Comments for Planning Application 21/01691/FUL

Application Number: 21/01691/FUL

Address: 85 New Road South Darenth KENT DA4 9AT

Proposal: Demolish existing garage and the erection of a 2 bedroom attached house and single storey side extension to existing property to enable the covered walkway to rear. Canopy porch to front.

Proposed Flank Elevation
Scale 1:100

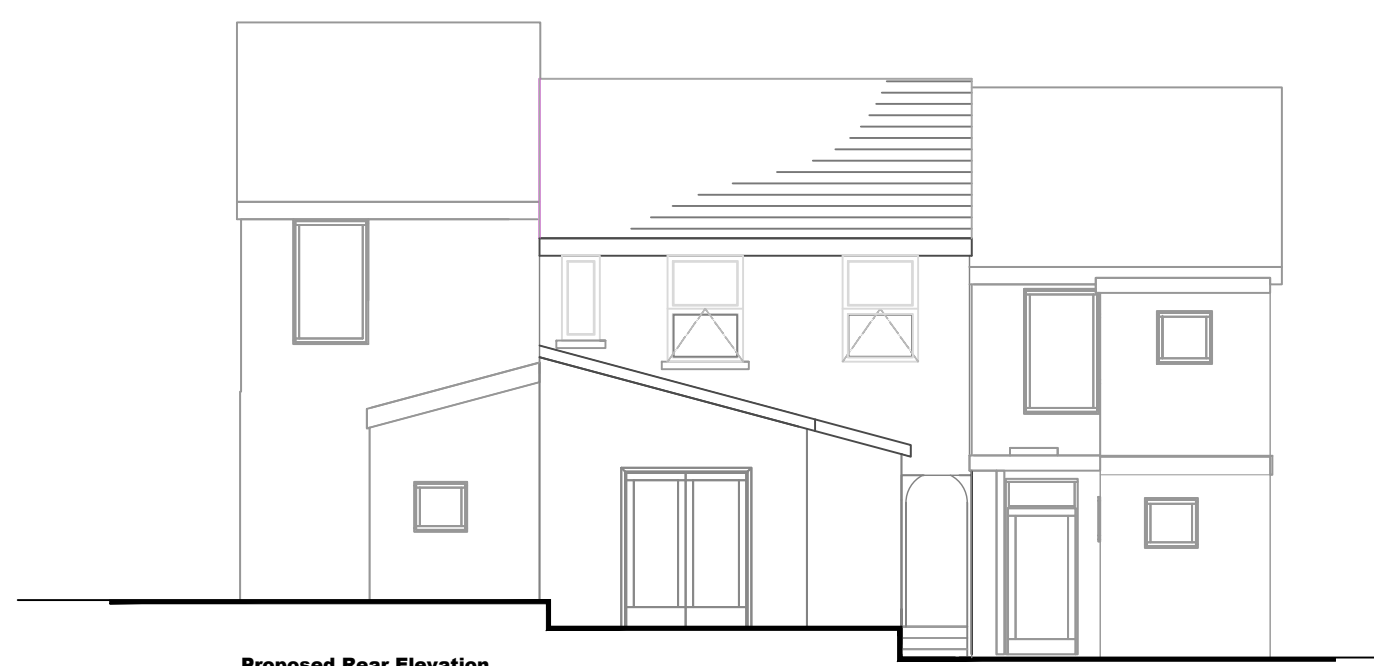
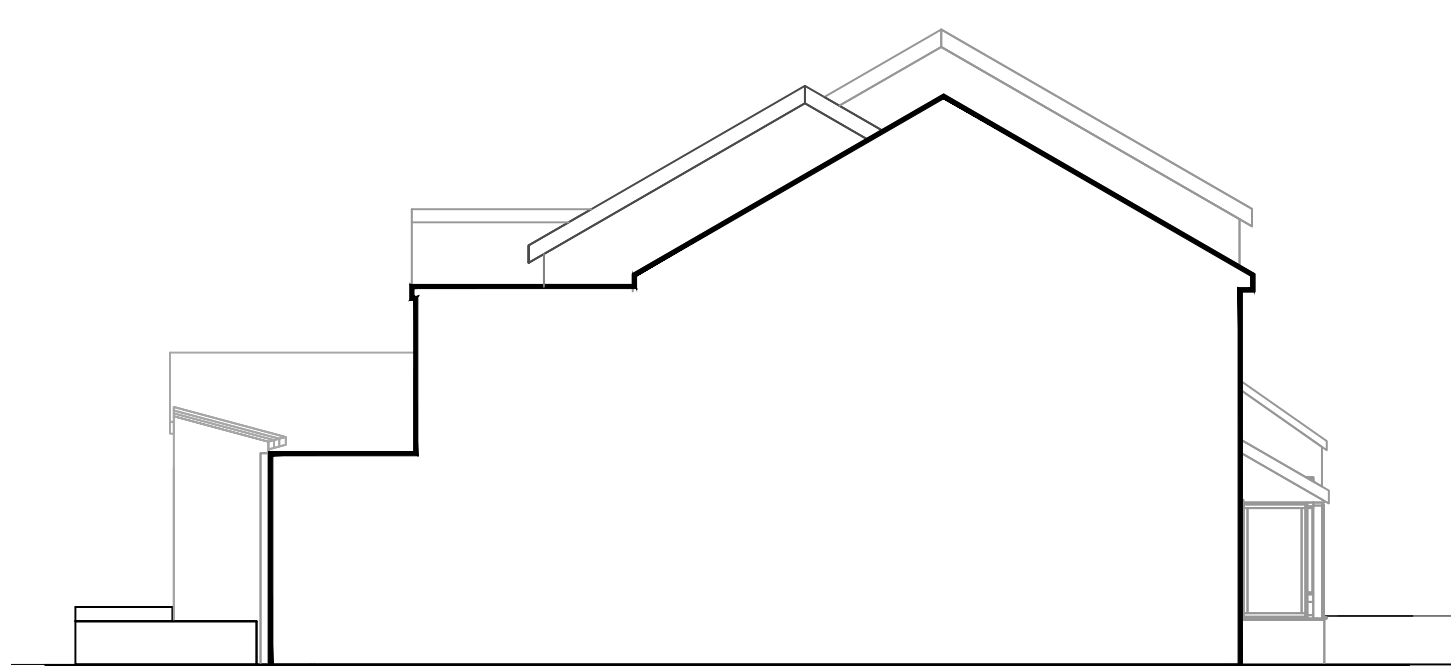
Comment: I object to this application mainly due to the loss of my right to light. I have a 5ft window in my kitchen which has been there for as long as I have lived there, six years, and for many years before that. I replaced the window four years ago because the lock was broken and the window wouldn't close properly. My downstairs living area is a through space from front to back, so losing the window, or having the window built across, in the kitchen would reduce my right to light by quite some way.
